Recommendation Report for Planning Permission for Works or Extension to a Dwelling

REF NO: P/36/22/HH

LOCATION: Sefter Cottage
Pagham Road
Pagham
PO21 3PX

PROPOSAL: Erection of two storey rear extension.

Drawing Number: 02

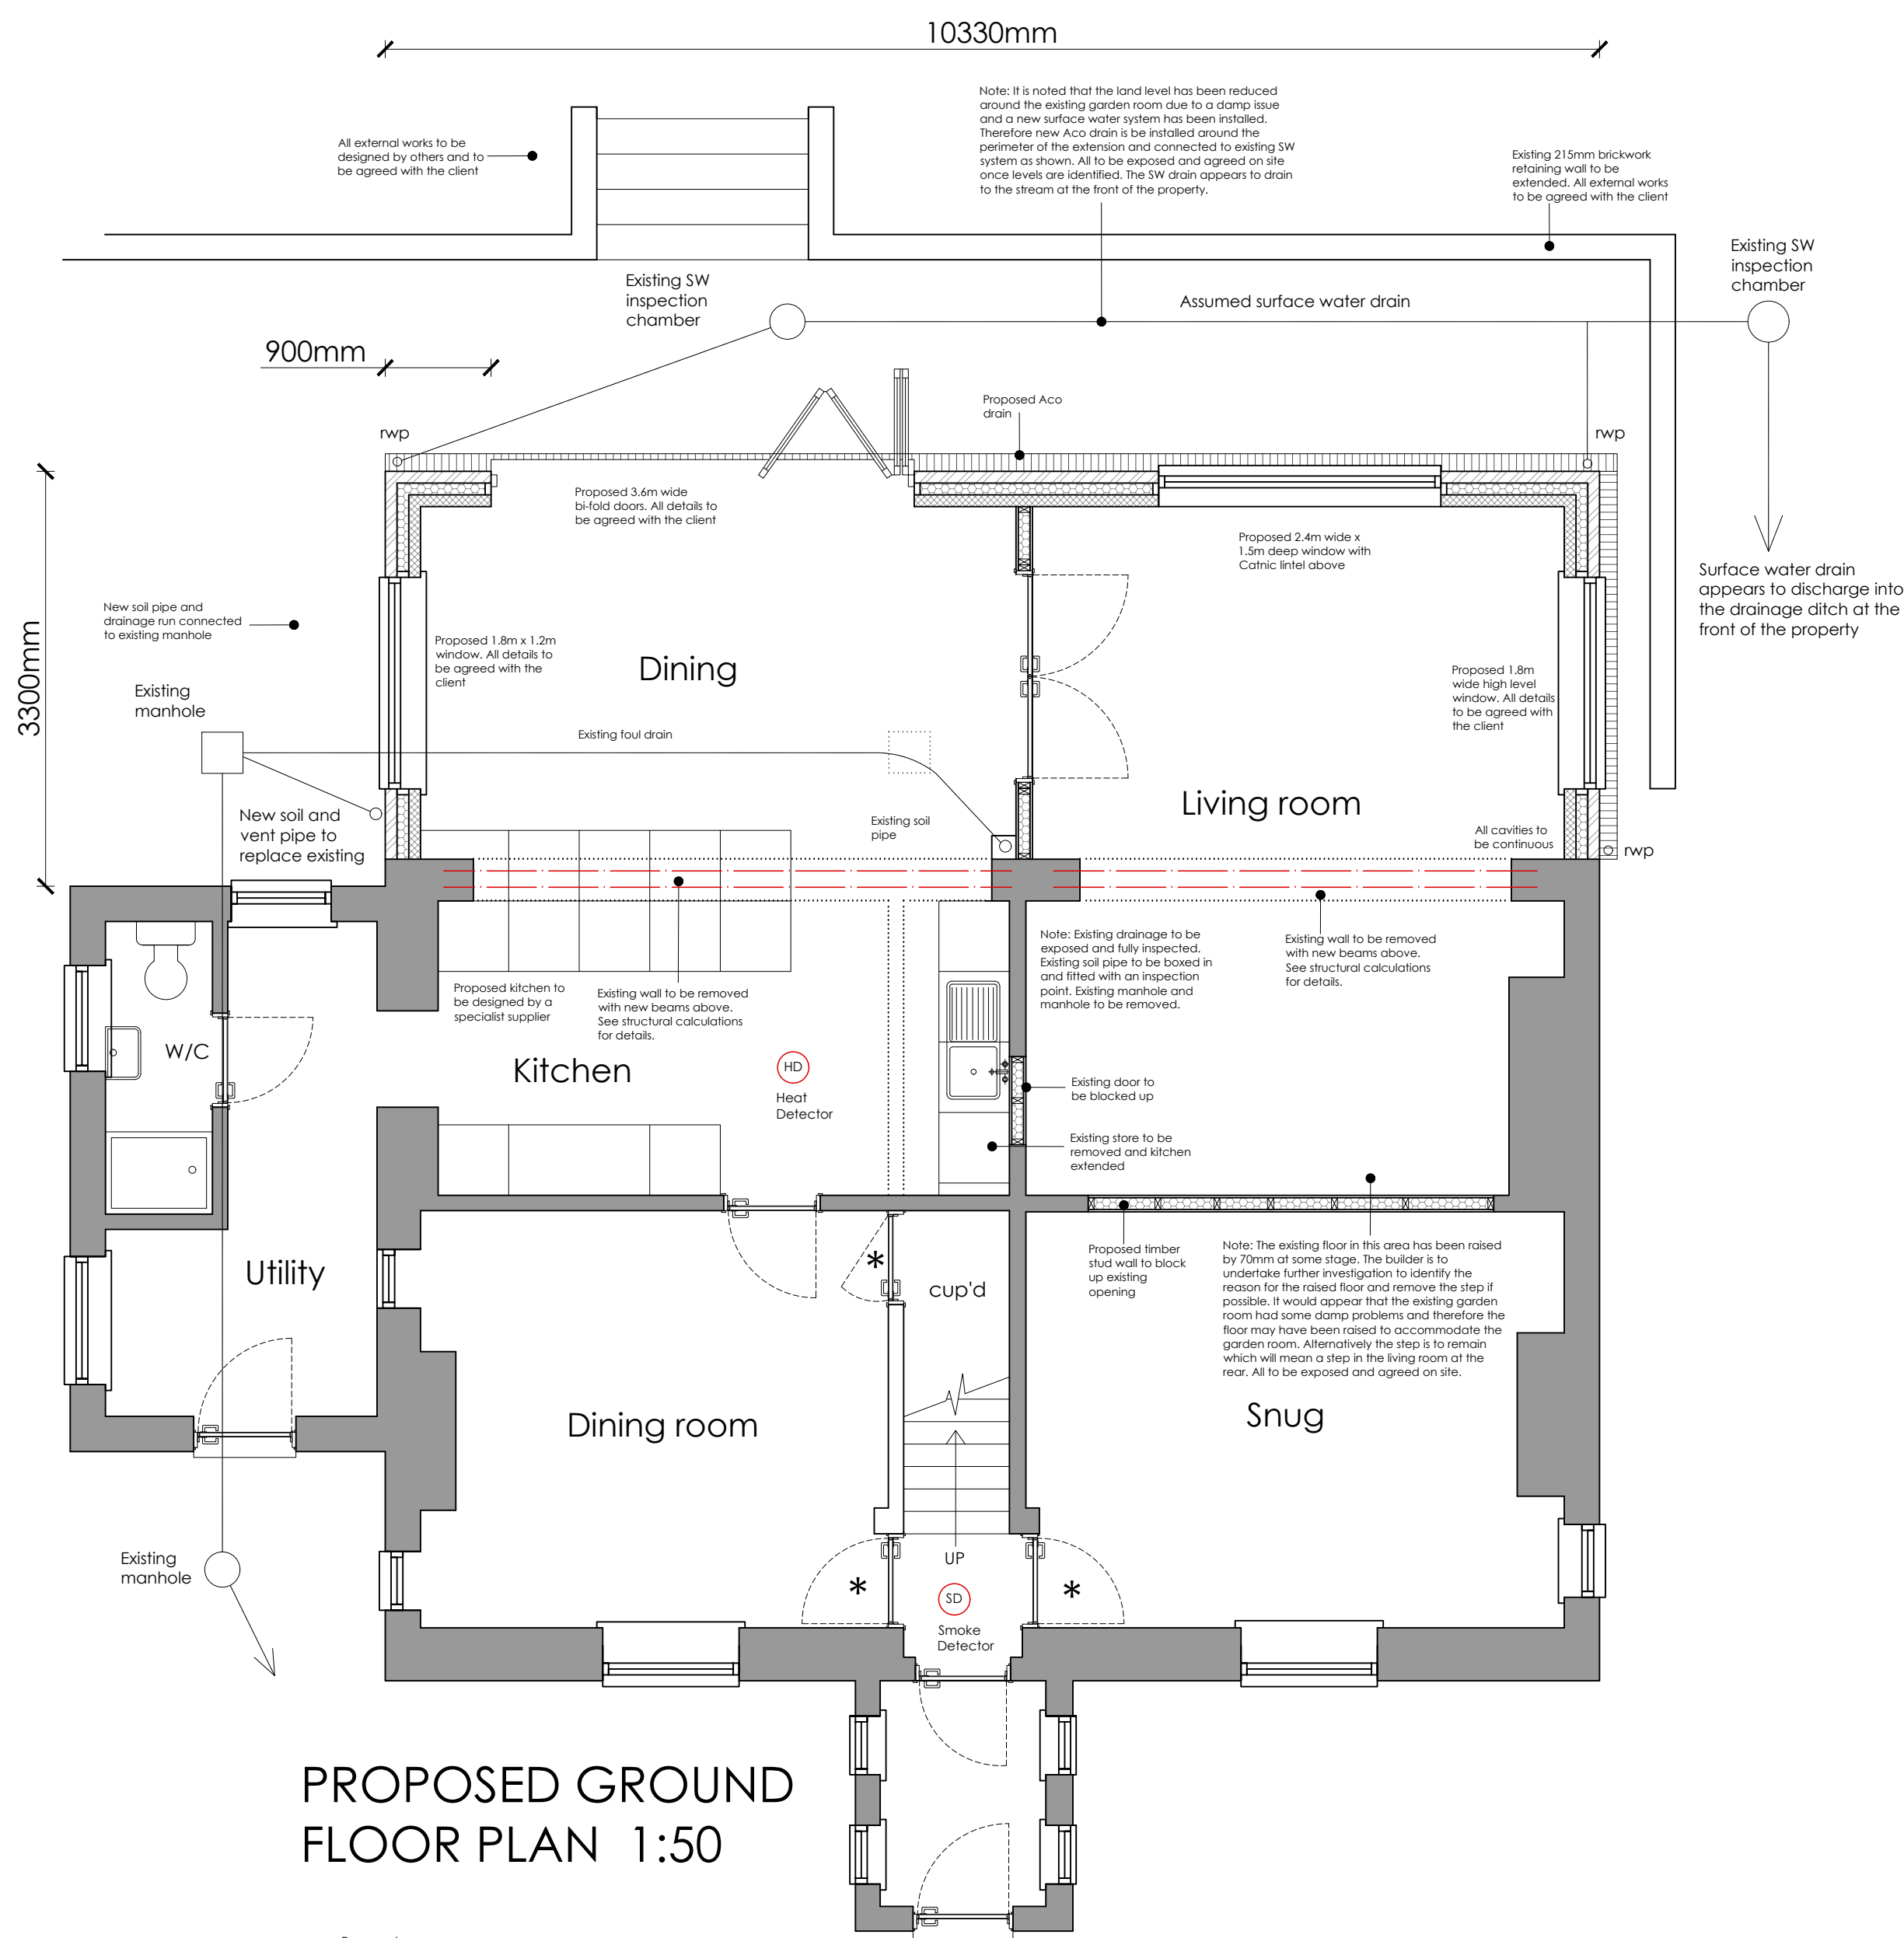
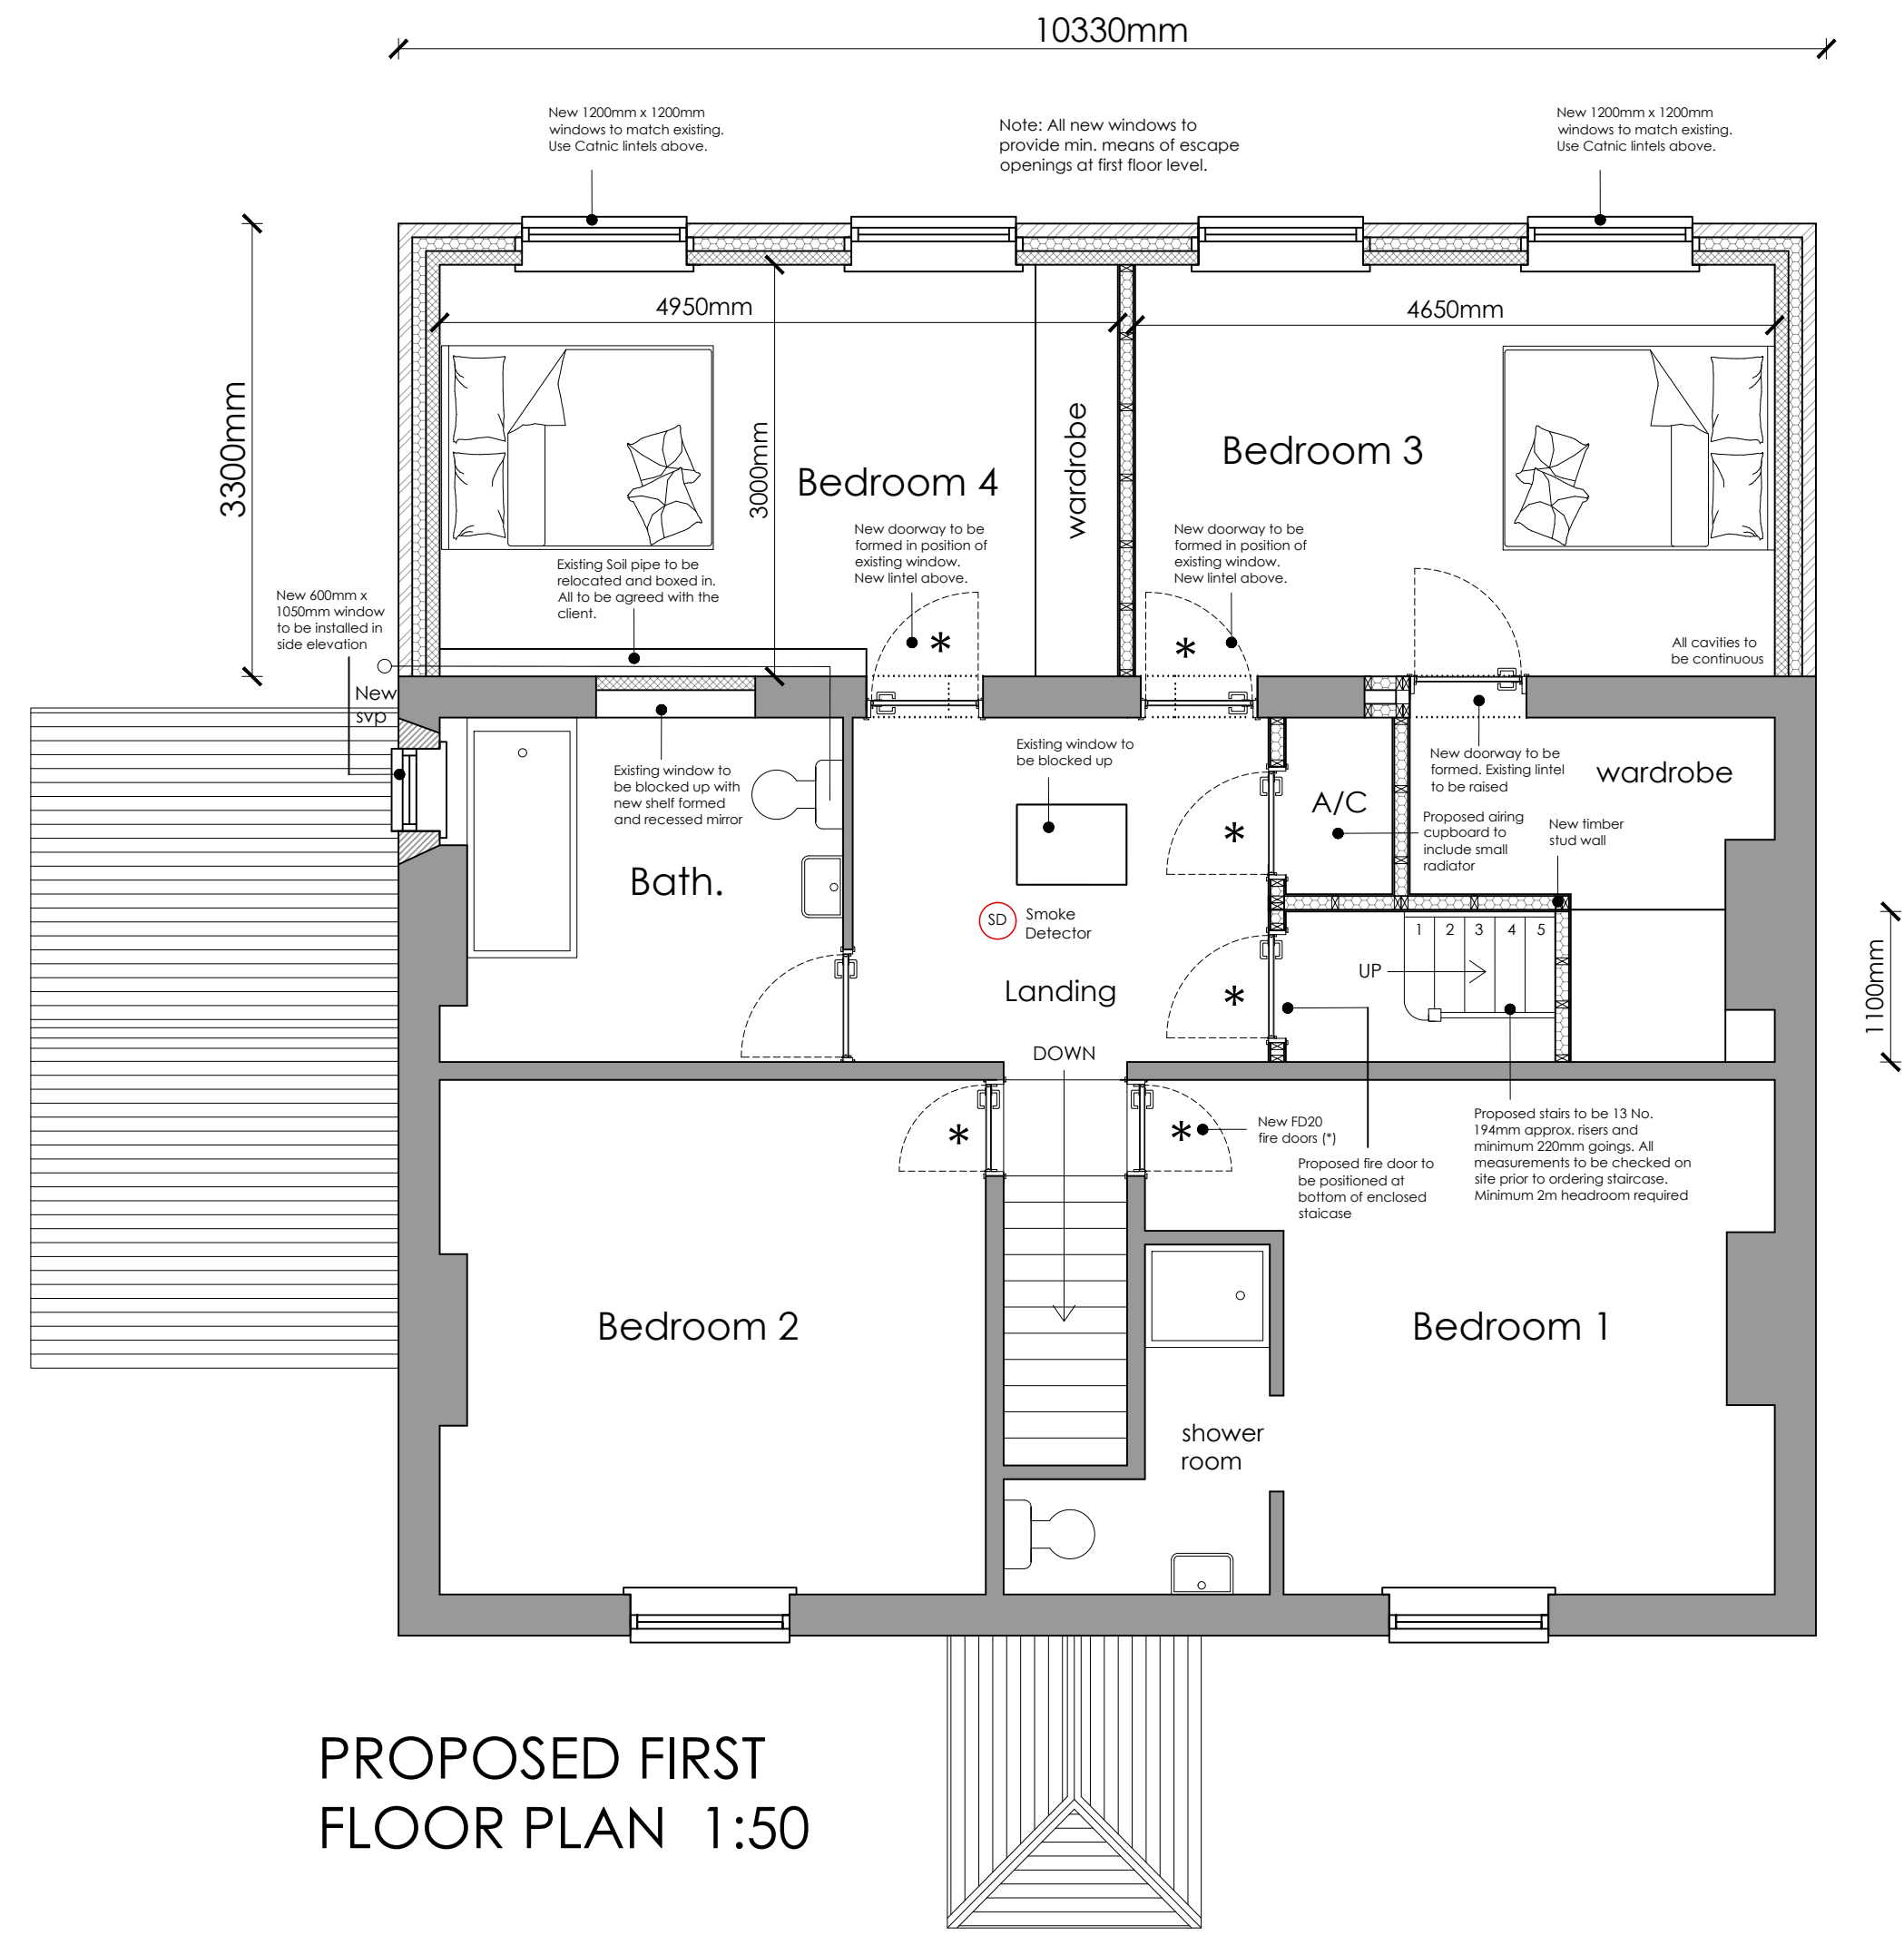
The dwelling is a detached two storey property with a single storey conservatory to the rear. The proposal will remove the conservatory and replace with a two storey extension that will run along the full rear elevation. Due to its siting, views are largely restricted from the wider area.

The two storey addition will feature 4 first floor windows to the rear elevation. This will provide views over the rear garden of the property. Due to their position, any views over the neighbouring garden are largely restricted when looking at a 45 degree angle and would not result in adverse overlooking. There will also be one additional window serving a bathroom to the first floor northern elevation. The window will not give rise to any overlooking with no nearby dwellings to this elevation.
